From: Martyn White
Sent: 07 December 2018 15:08
To: Planning.Responses
Cc: Simon Davis
Subject: AW/331/18/DOC

AW/331/18/DOC

The current application relates to two conditions applied to AW/187/18/PL and relates to the provision of:

WINDOW SECTION.

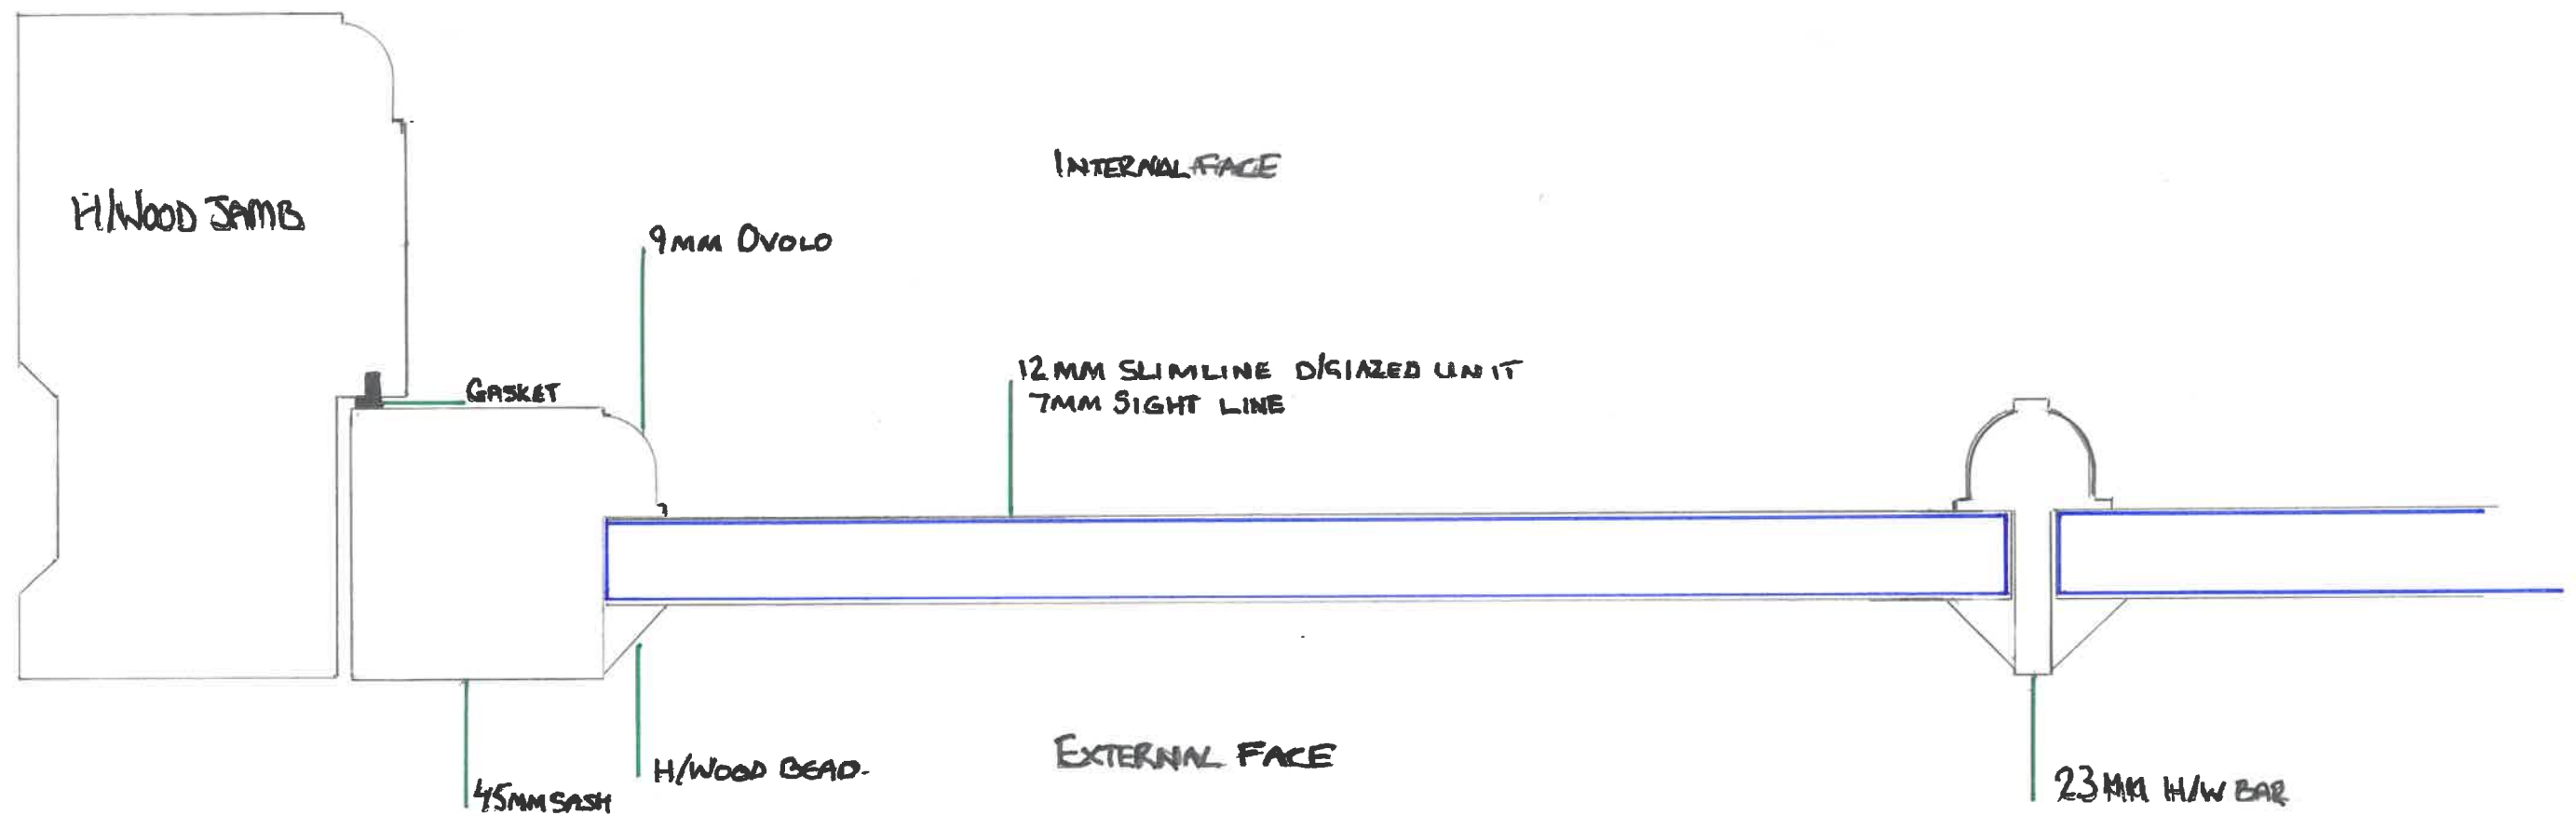
With regard to the new joinery, I note that a list of materials has been provided, along with two photographs of similar doors/windows on the existing property. Reference to the use of hardwood is acceptable, as is the colour (white). However, as only two photographs have been provided, as opposed to some form of scaled drawing indicating measurements, it is not clear if the proposed windows will be a true like-for-like copy, or merely similar in appearance. It is considered that some greater certainty would be required.
